MMC: FW: Shaws TCP (CMP) - Status

Hi Nell – The following is a status update of previous comments based upon new information submitted by the applicant. Thanks

Maine Medical Center Site Enabling PH2		Phase 1 Work Zone Traffic Control Plan		FIGURE <b>1C</b>
Shaw Brothers Construction, Inc. 341 Mosher Road, P.O. Box 69 Gorham, Maine 04038 (207) 839-2552				
		DRAWN: M.E.	DATE: 4/30/19	
		DESIGNED: -	SCALE: 1"=100'	
		CHECKED: -	FILE: -	
		FILE LOC: -

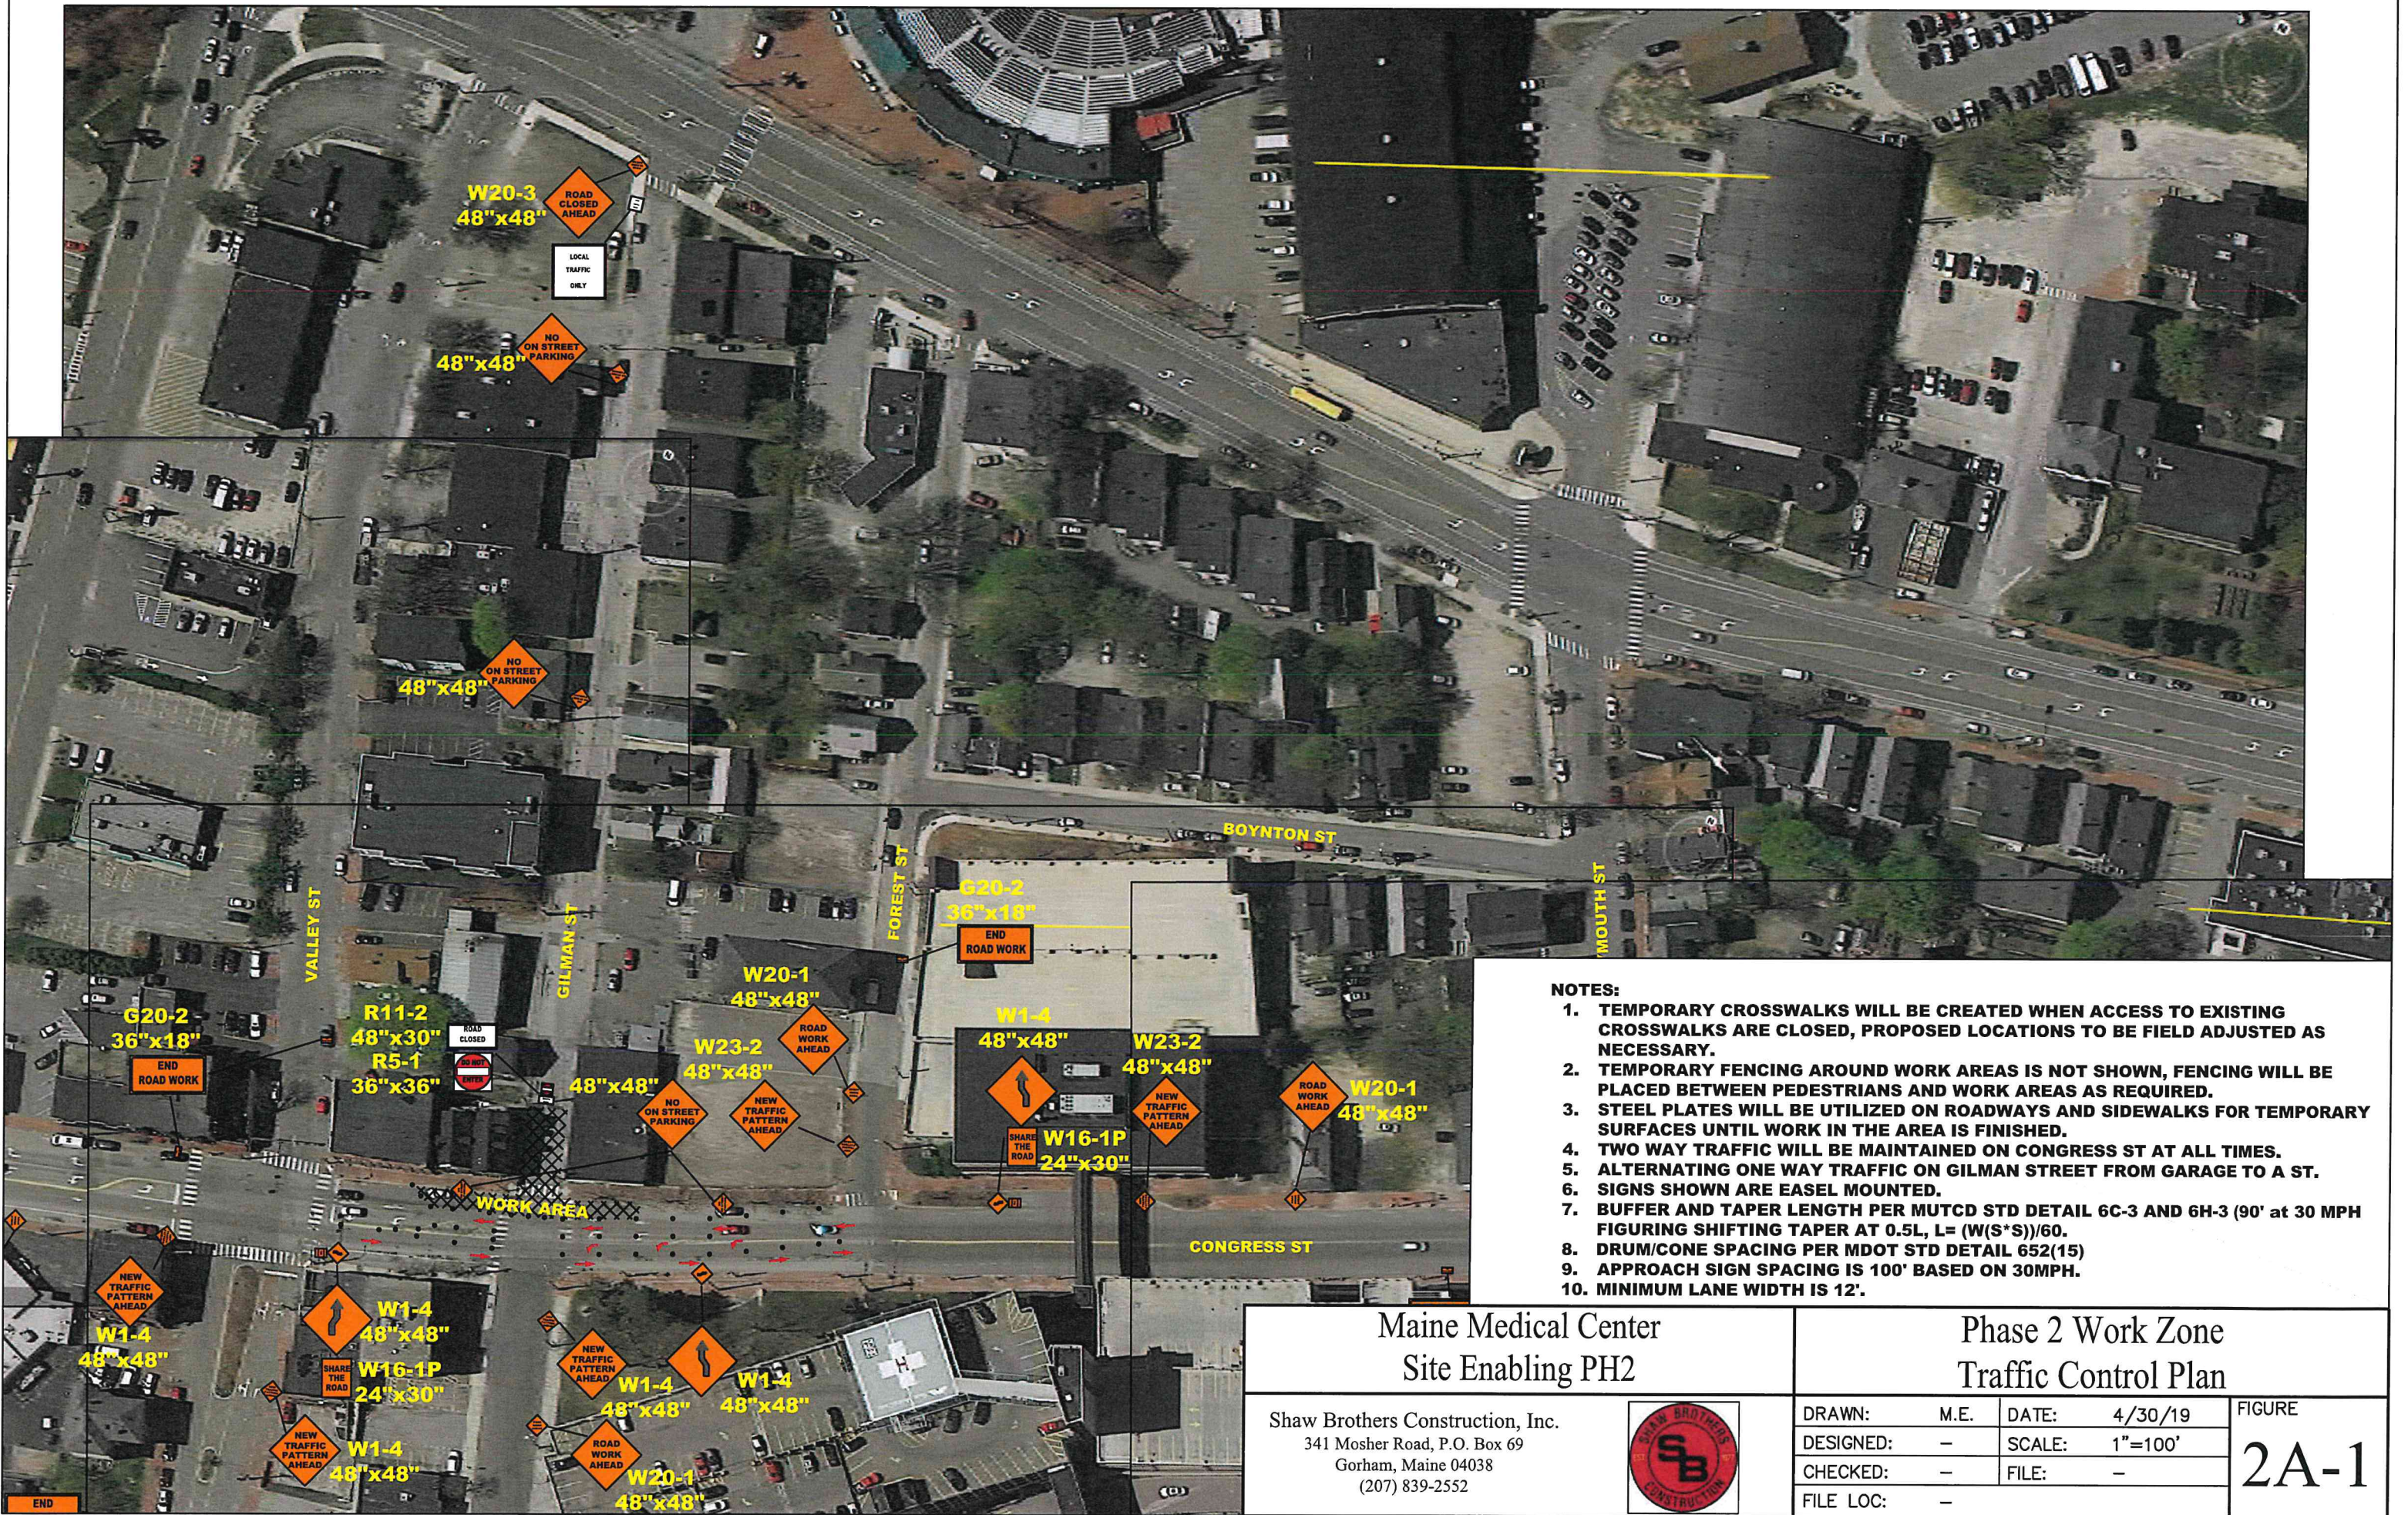
- Seems like some on-street parking could be allowed. **To be determined in the field. I find this acceptable**
- Confirm ADA width requirements are met on Forest due to pole constraints. **Notes that it is 4-foot and will be field checked. I find this acceptable, but it should be acknowledged that all facilities shall meet ADA requirements**

FIGURE  
**2A-1**

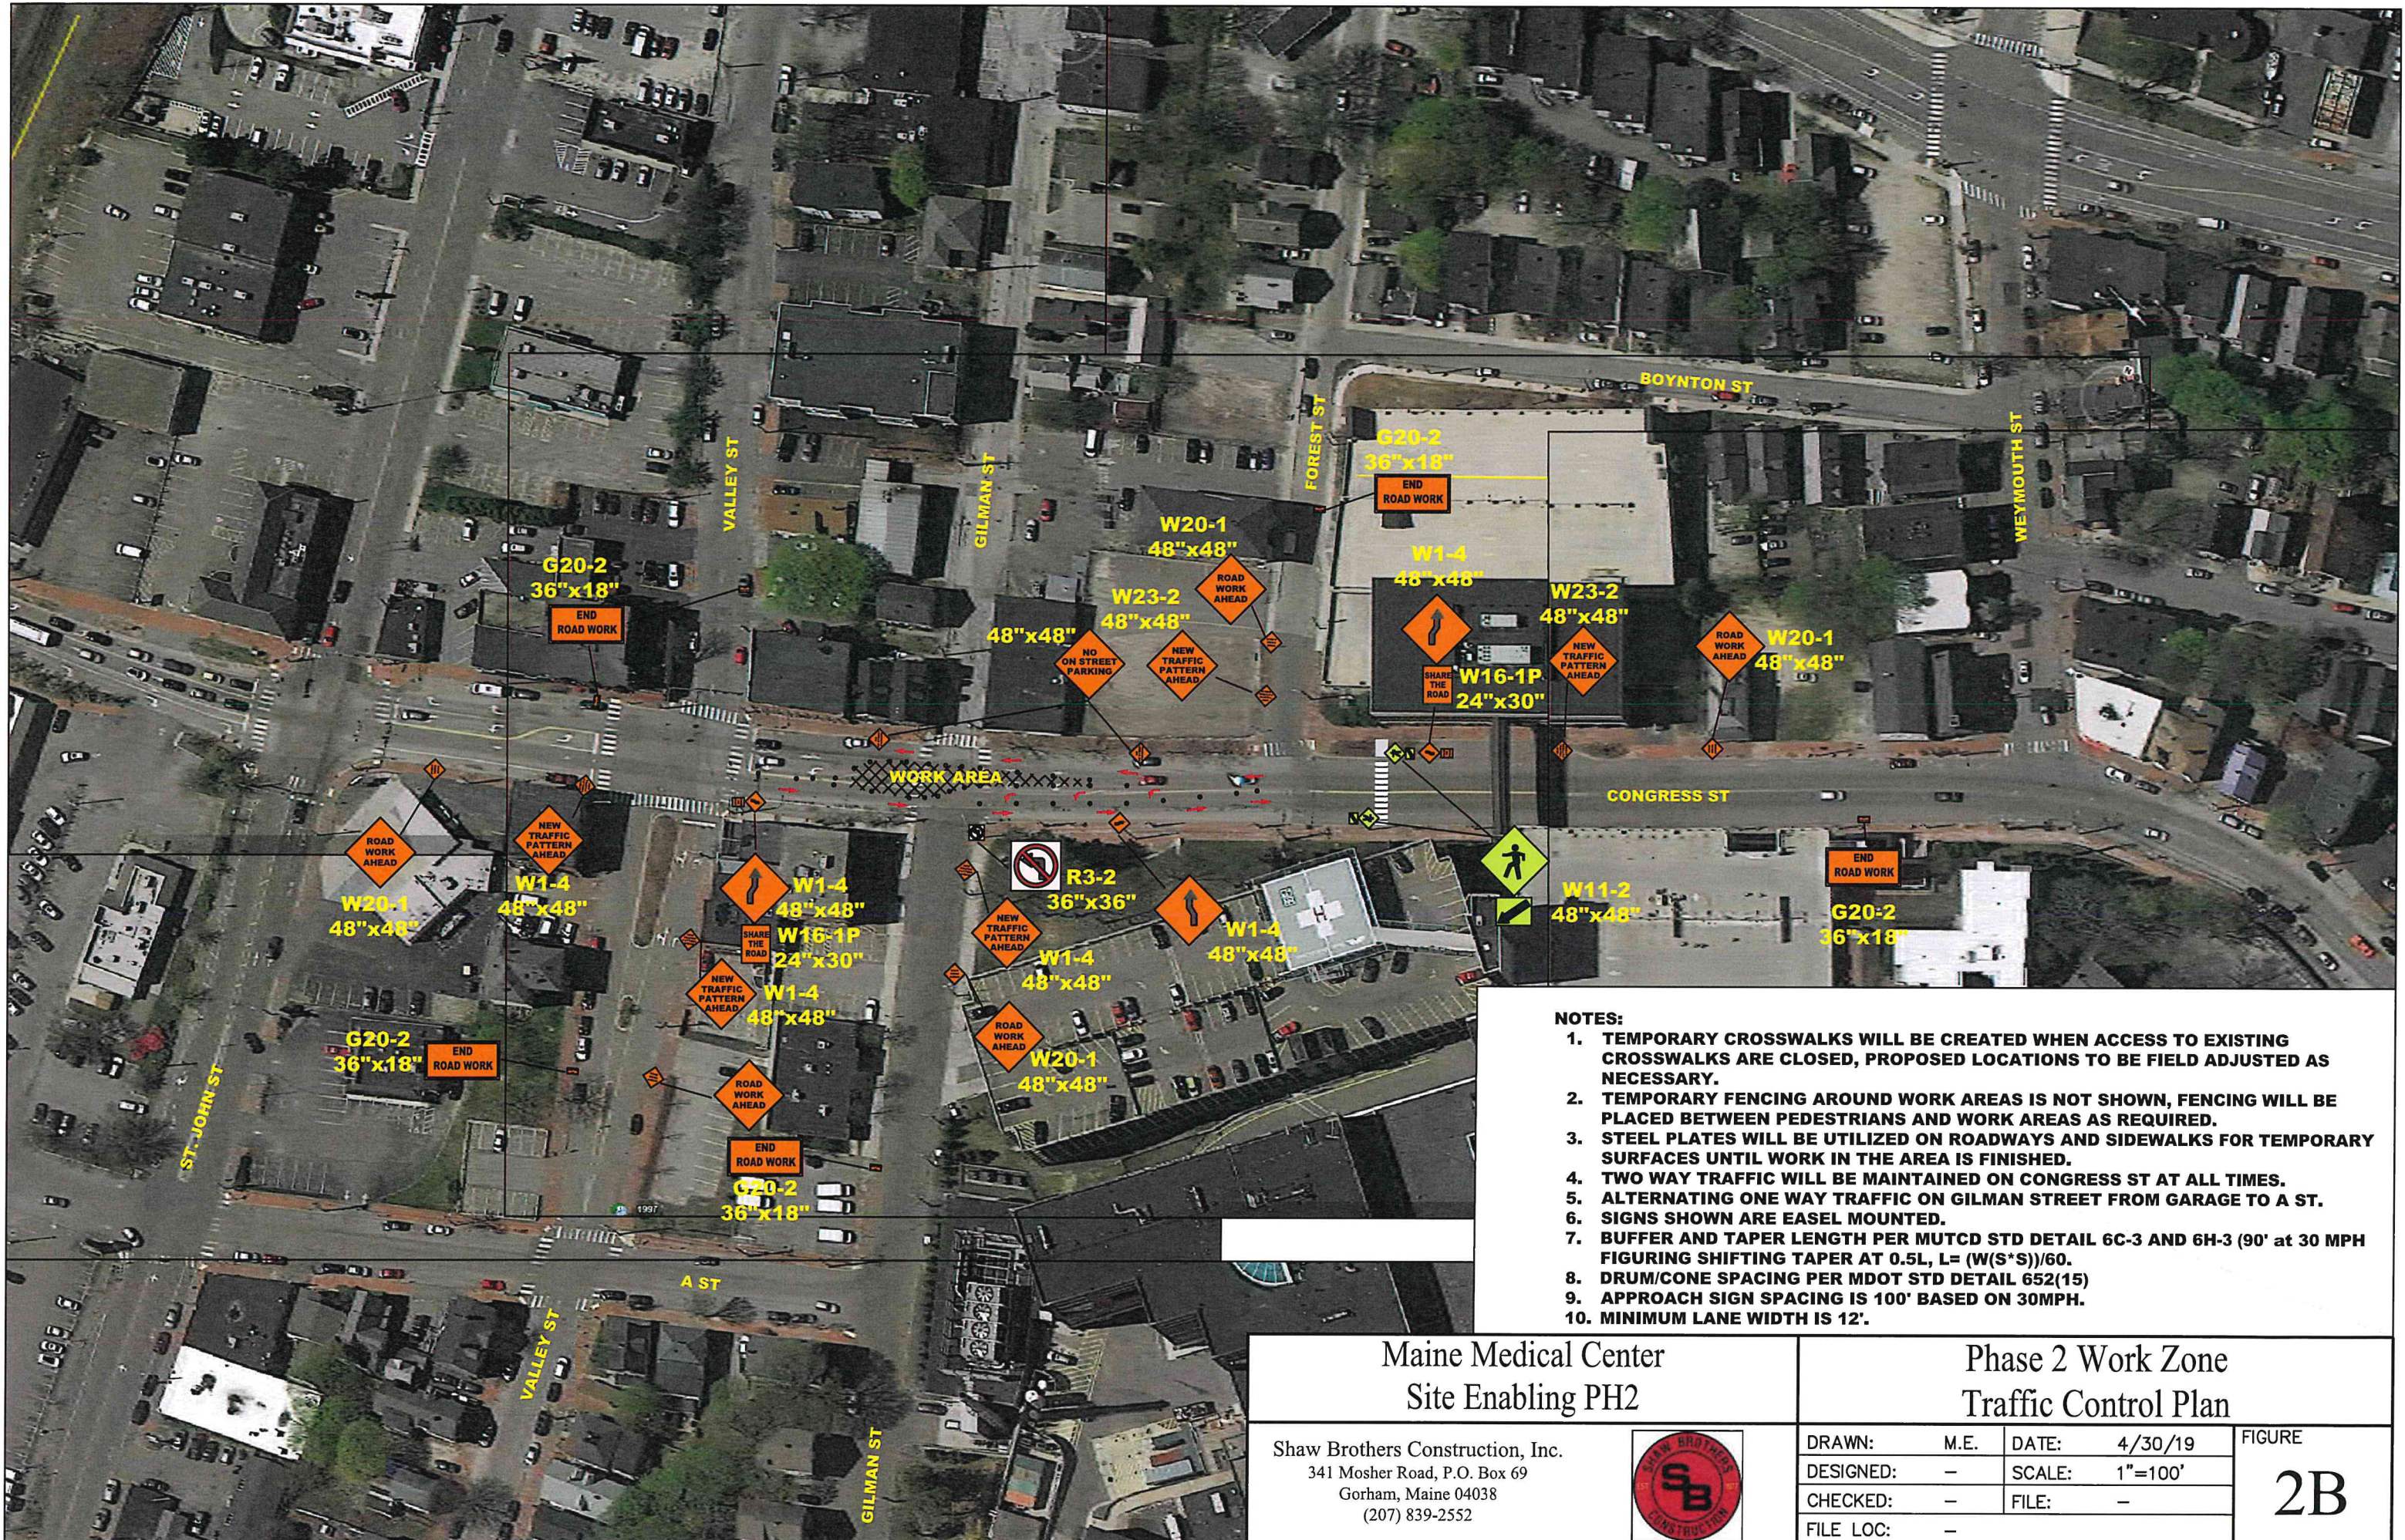
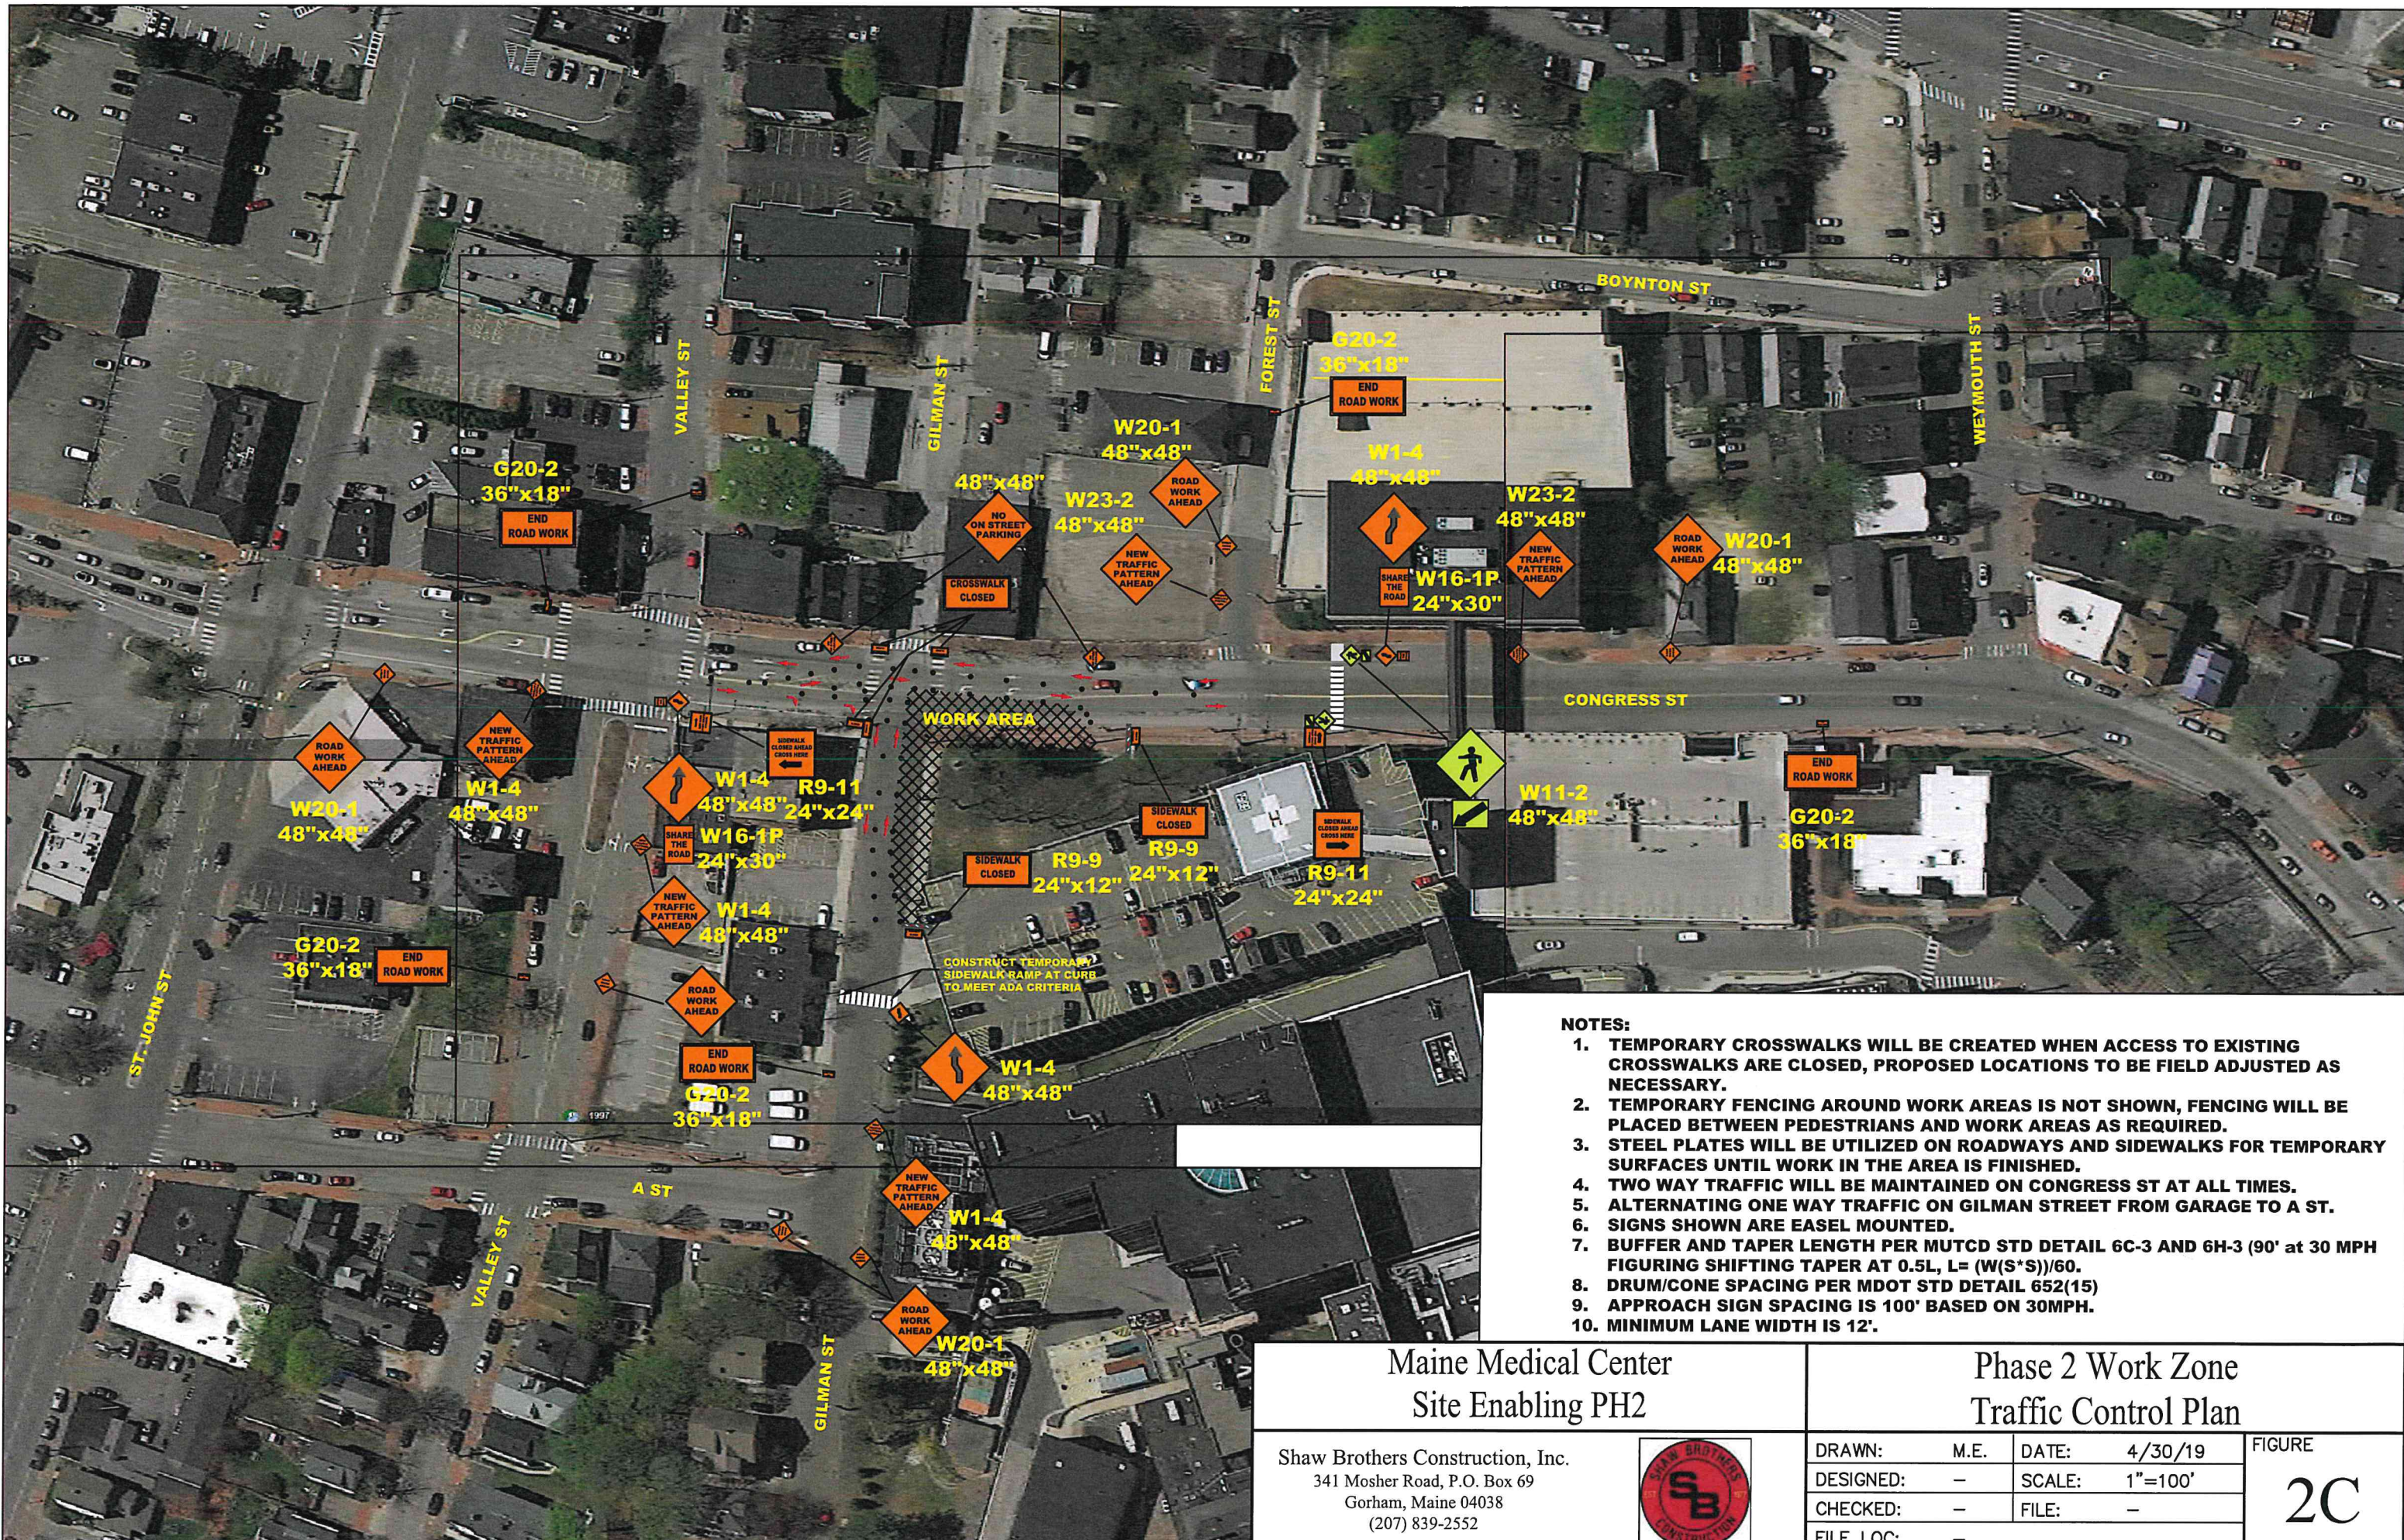
- Is the sidewalk closed on the north side of Congress at Gilman? **Clarified. I have no further comment**
- How is traffic being managed on Gilman between the closure and Park Avenue? Greater detail is required. **This needs more detail. Is parking being removed? Conflicting signs need to be addressed (e.g. one-way at Park). How are truck deliveries/activity being managed?**
